Ask for:	Erika Davies
Telephone:	01832 742207
Planning Services	
Our Ref:	NE/21/00733/FUL
Your Ref:	PP-09797007
Date:	11 May 2021

Proposal : **Retrospective planning application for detached garage/home office/games room to allow for the change of use to dwelling/ office /outside store/games room at Lock House Pilton Road Lilford Peterborough Northamptonshire PE8 5SG .**

I refer to the above application received on **30 April 2021** but have to advise you that it is **INVALID/INCOMPLETE**. In order to enable further progress to be made, please supply the following:

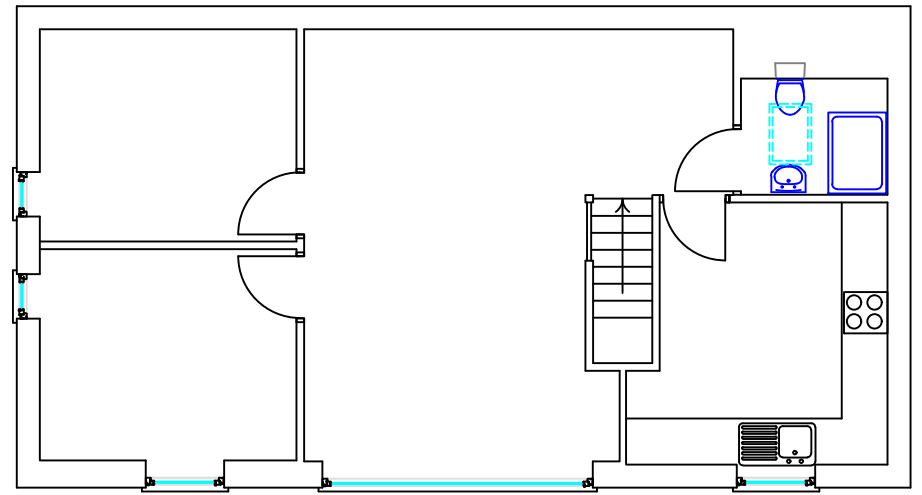
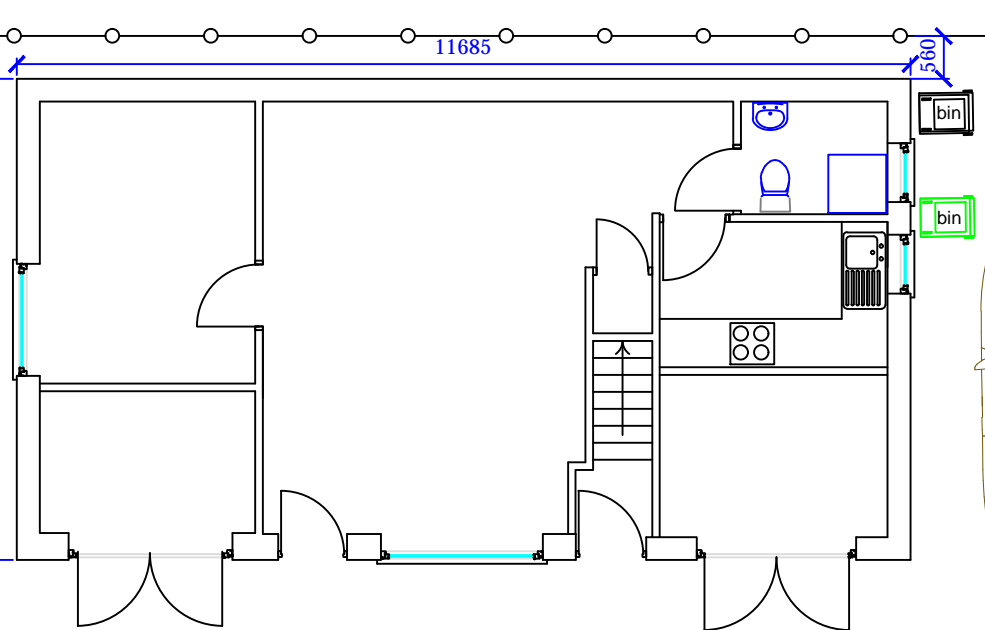
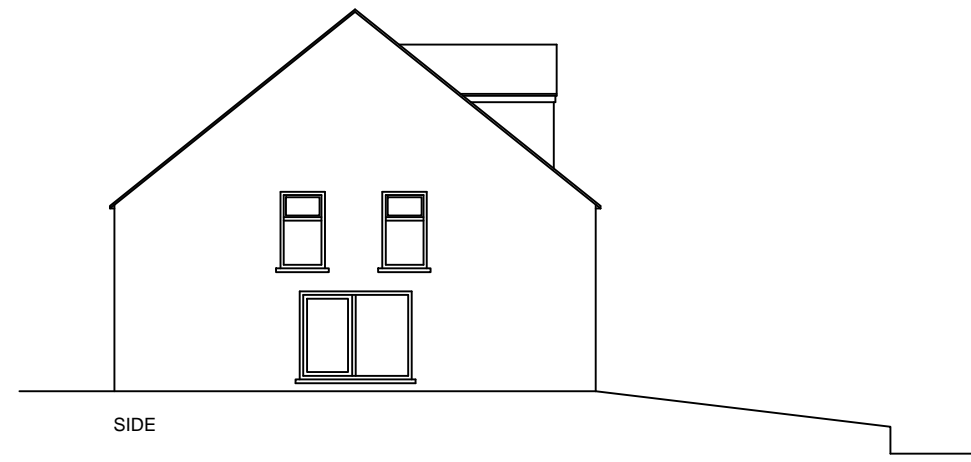
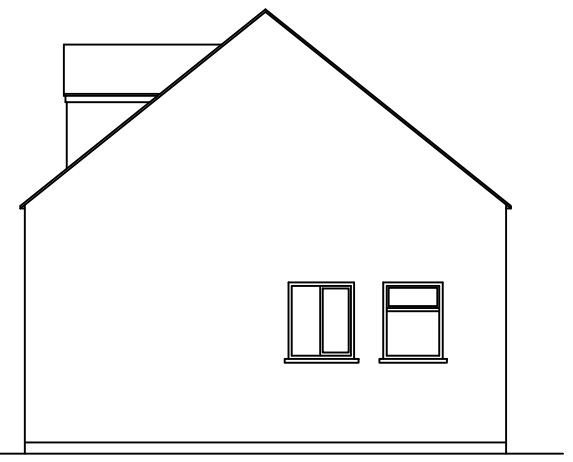
Please provide amended drawings including all relevant dimensions of the proposal:

- Dimensions for the floor plan
- Dimensions for the elevations annotated with all height dimensions
- Up to date photographs could also be useful during the determination of this application

BLOCK PLAN 1:500

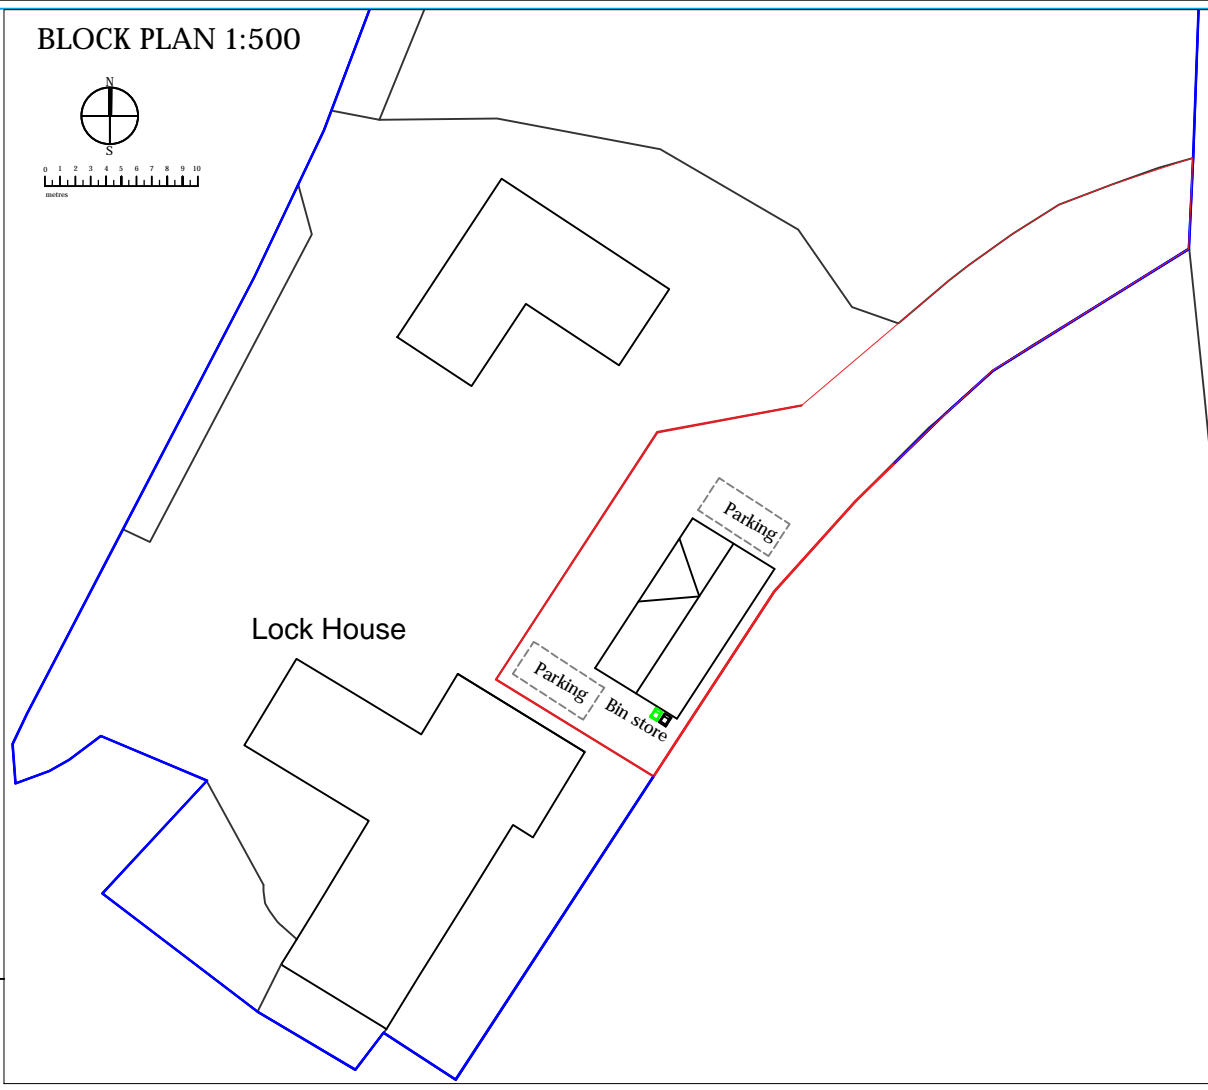
2. As per our local requirements the site plan (to a scale of 1:200 or 1:500) should show your proposals for parking and storage and collection of waste and recyclables. Please provide an amended site plan.
3. As per our published Local Requirements, "All plans and drawings must have all relevant dimensions of the key elements of the proposal clearly written. This includes the height, length, width and (if relevant) the distance from the site boundary of any proposed works. We require this so that the proposed dimensions are clear when plans are viewed online." This is required as we now run a completely paperless planning office.

SITE LOCATION 1:1250

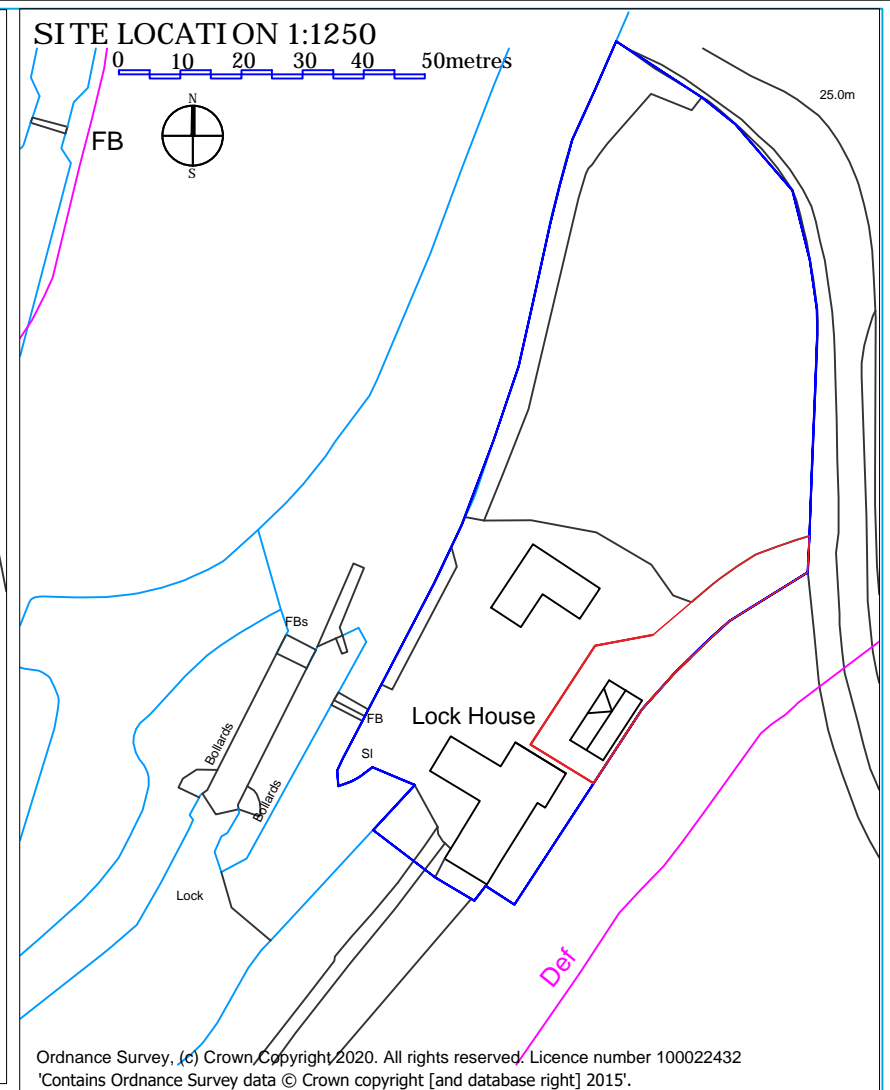
1. Thank you for the location plan submitted with your application, unfortunately it does not fully comply with our local requirements because access from the public highway has not been included on the red line. As per our local requirements "the red line must include all land necessary to carry out the proposed development (including the land required for access to the site from a public highway...)".

Please provide an amended location plan showing the land required for access to the site from the public highway included on the red line.

Additionally, as it appears that Ordnance Survey map data has been used in the submitted site and location plans please provide a copyright statement on the drawing e.g. 'Contains Ordnance Survey data © Crown copyright [and database right] 2015'. This is required as the Ordnance Survey is tightening up on infringement on their copyright.
